OXFORDSHIRE COUNTY COUNCIL'S RESPONSE TO CONSULTATION ON THE FOLLOWING DEVELOPMENT PROPOSAL

Application no: 22/02866/OUT

Proposal: OUTLINE planning application for up to 120 dwellings, vehicular and pedestrian access off Ploughley Road, new pedestrian access to West Hawthorn Road, surface water drainage, foul water drainage, landscaping, public open space, biodiversity and associated infrastructure. Access off Ploughley Road is not reserved for future consideration

Location: Land East Of, Ploughley Road, Ambrosden

Scale 1/1000 & 1/100 @ A1 Date 21.11.2022 Revision  
Drawn AH Checked SI Sheet Size A1  
**P01**

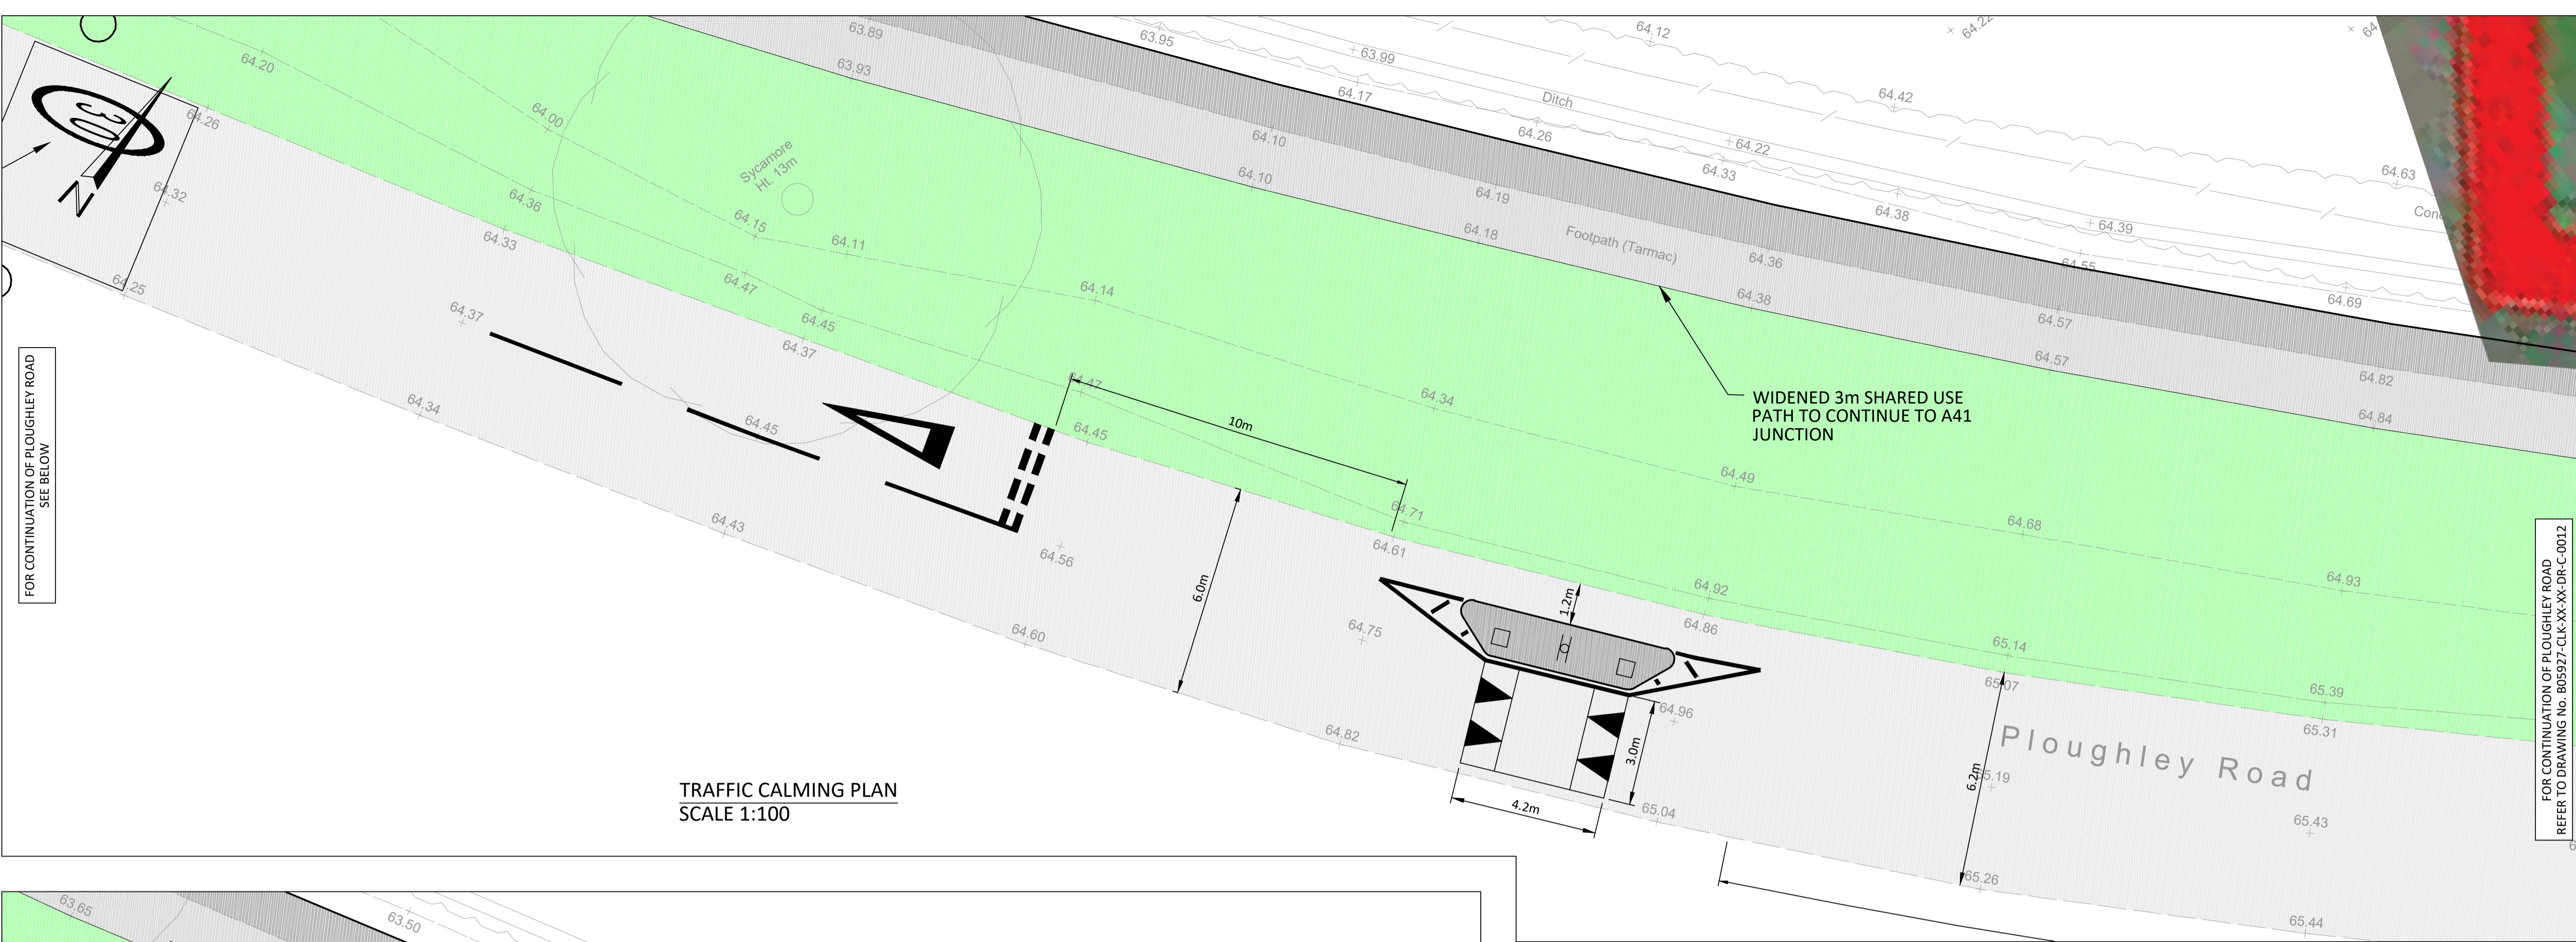
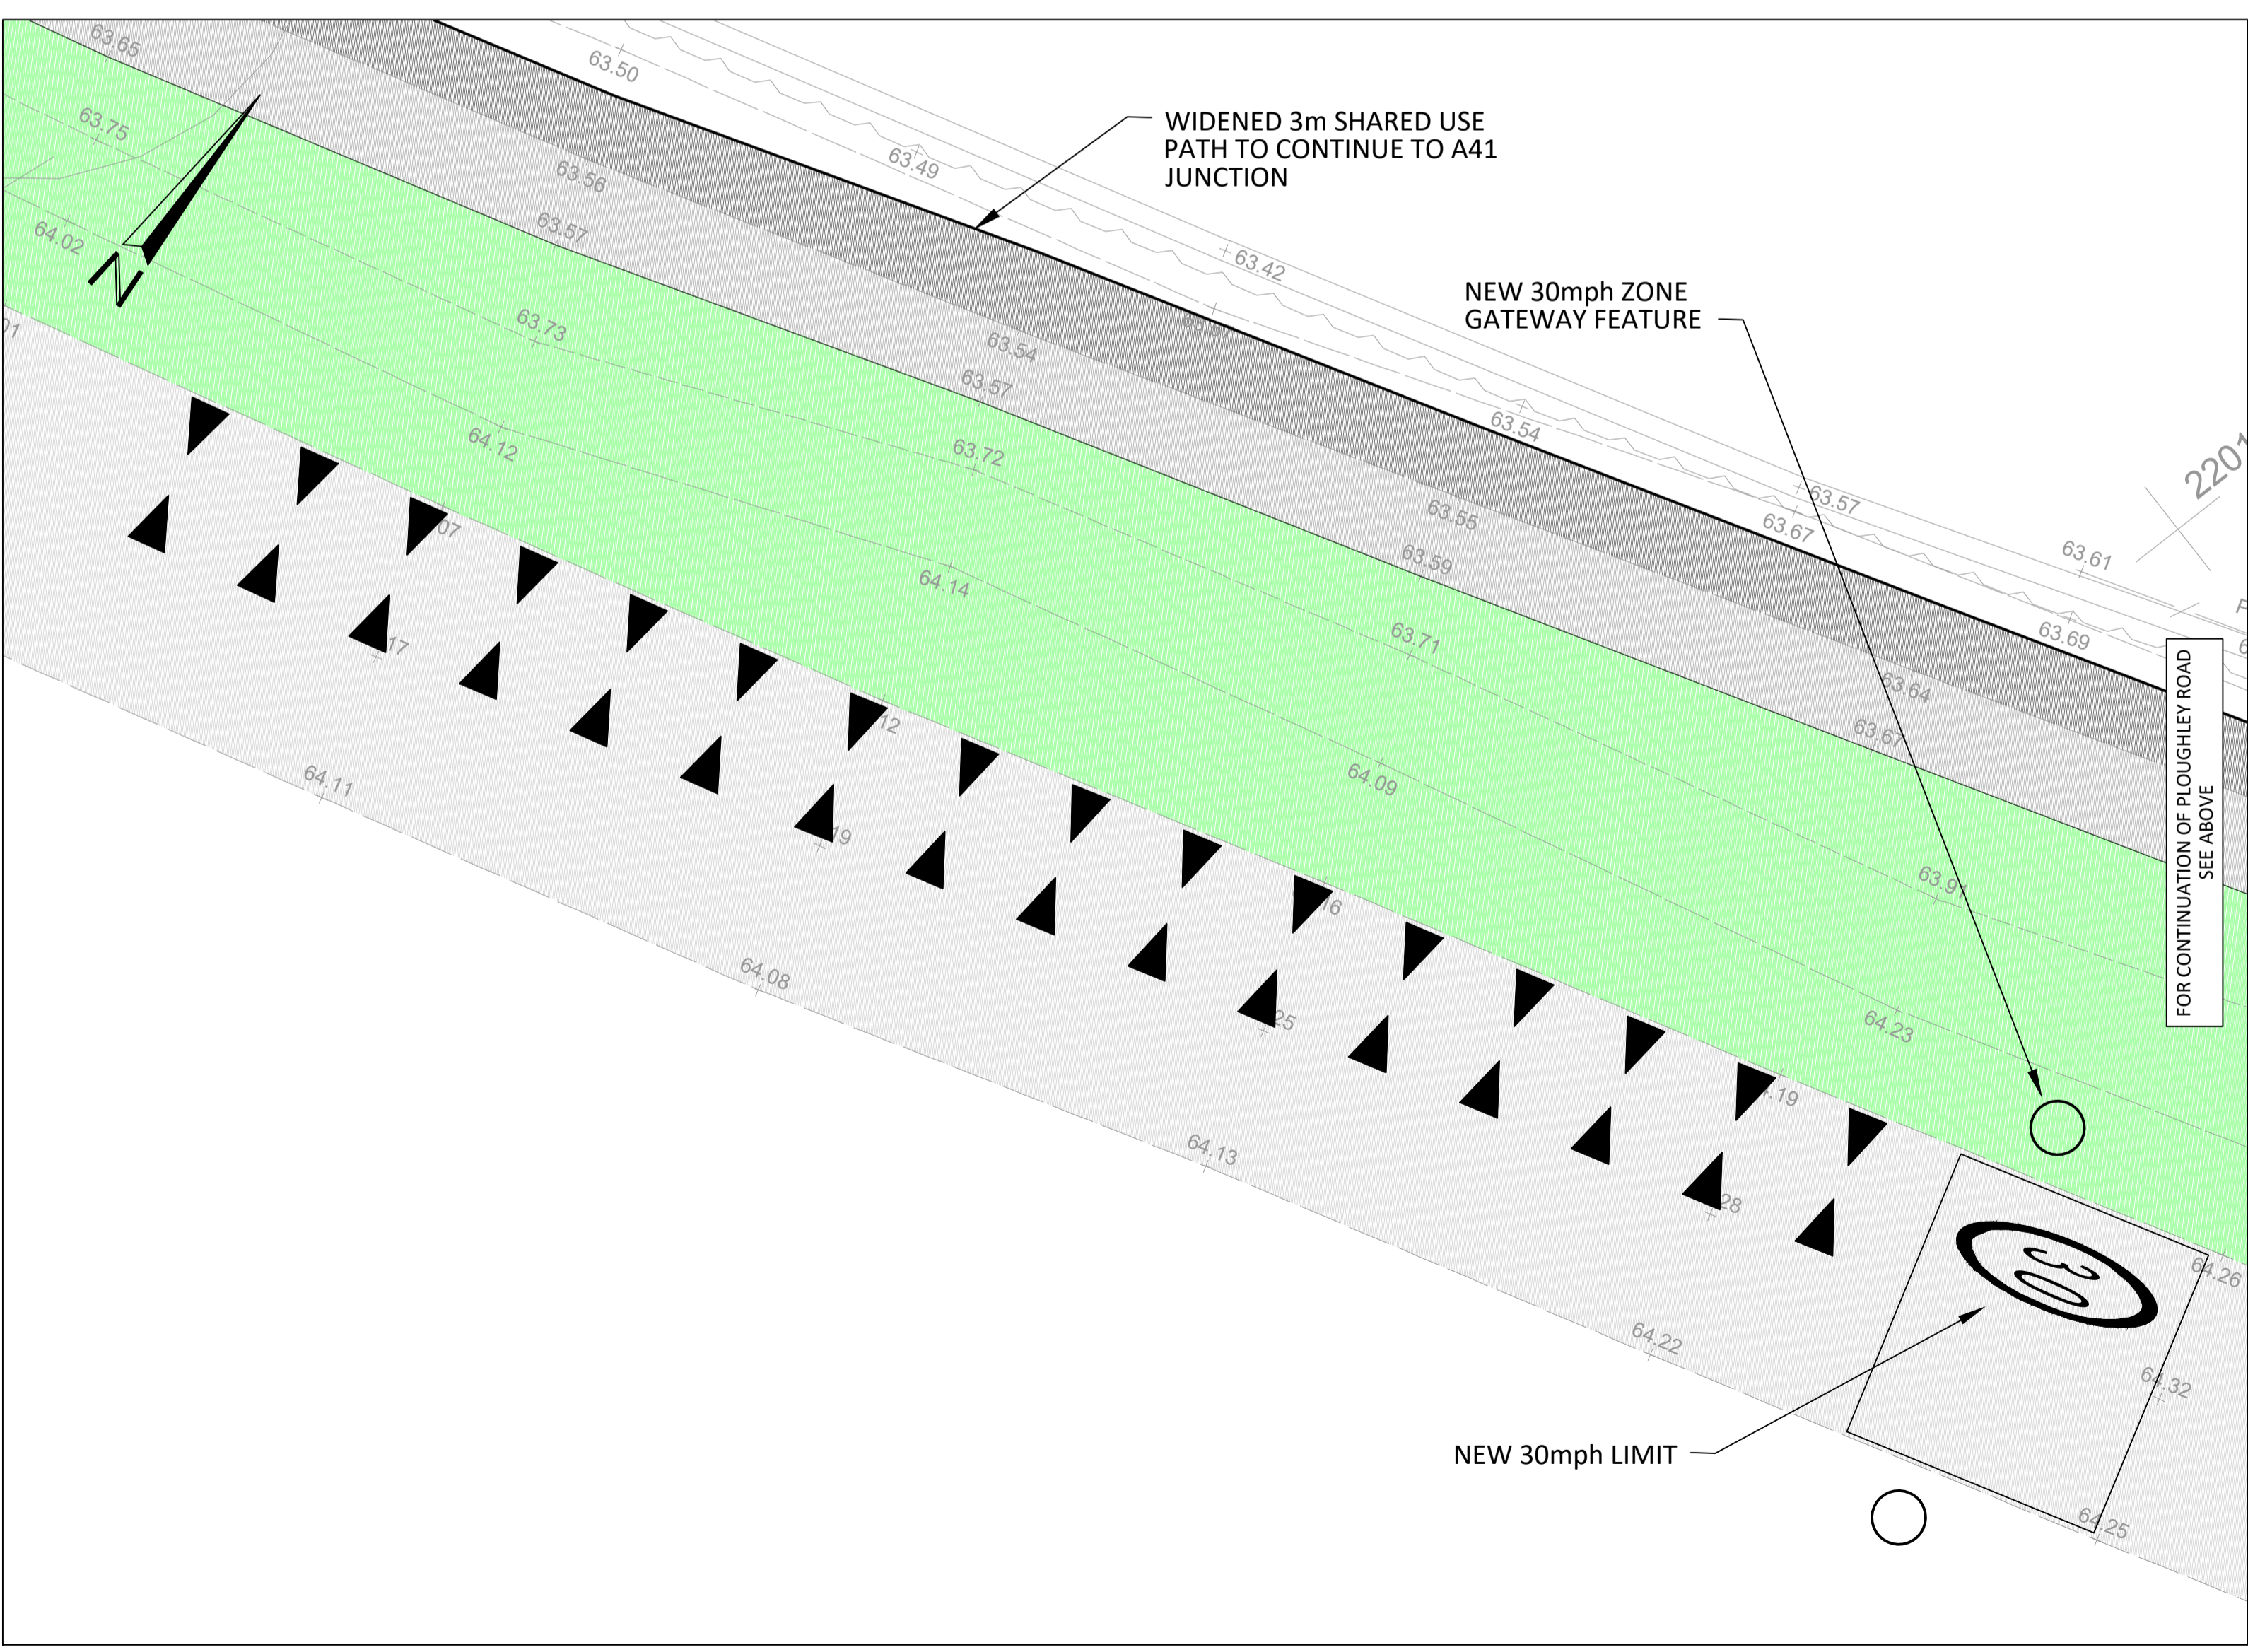
In order to reduce the approach speed of southbound vehicles, a build-out traffic calming feature has been introduced to the north of the site access. This feature replicates those on the Ploughley Road at the south entrance to the village. The effect of the build-out is three-fold:

1. Some vehicles will have to slow or stop to give way to northbound traffic
2. The full-width cushion will encourage vehicles to reduce speed
3. Southbound vehicles will be diverted to the northbound lane when passing the build-out, so will be more visible from the site access.

This calming feature will be visible to northbound traffic leaving the village and so will tend to dampen vehicle speeds towards and past the site access. The length of road up to and just past the feature will be reduced to a 30mph limit.

- Traffic-calming measures adjacent to the site access on Ploughley Road (as shown indicatively on Clarkebond drawing B05927-CLK-XX-XX-DR-C-0012 Rev. P02).

- Two bus stops on Ploughley Road. Each to comprise a two-bay shelter, Premium standard pole, flag and timetable case. The shelters are to include electrical connections for a future real time information screen (by others) (as shown indicatively on Clarkebond drawing B05927-CLK-XX-XX-DR-C-0012 Rev. P02).

- A crossing of Ploughley Road to the northbound bus stop (as shown indicatively on Clarkebond drawing B05927-CLK-XX-XX-DR-C-0012 Rev. P02).
- Improvements to the bridleway between the site and West Hawthorn Road (as shown indicatively on Clarkebond drawing B05927-CLK-XX-XX-SK-C-0001 Rev. P01). This may be on a separate short-form S278.
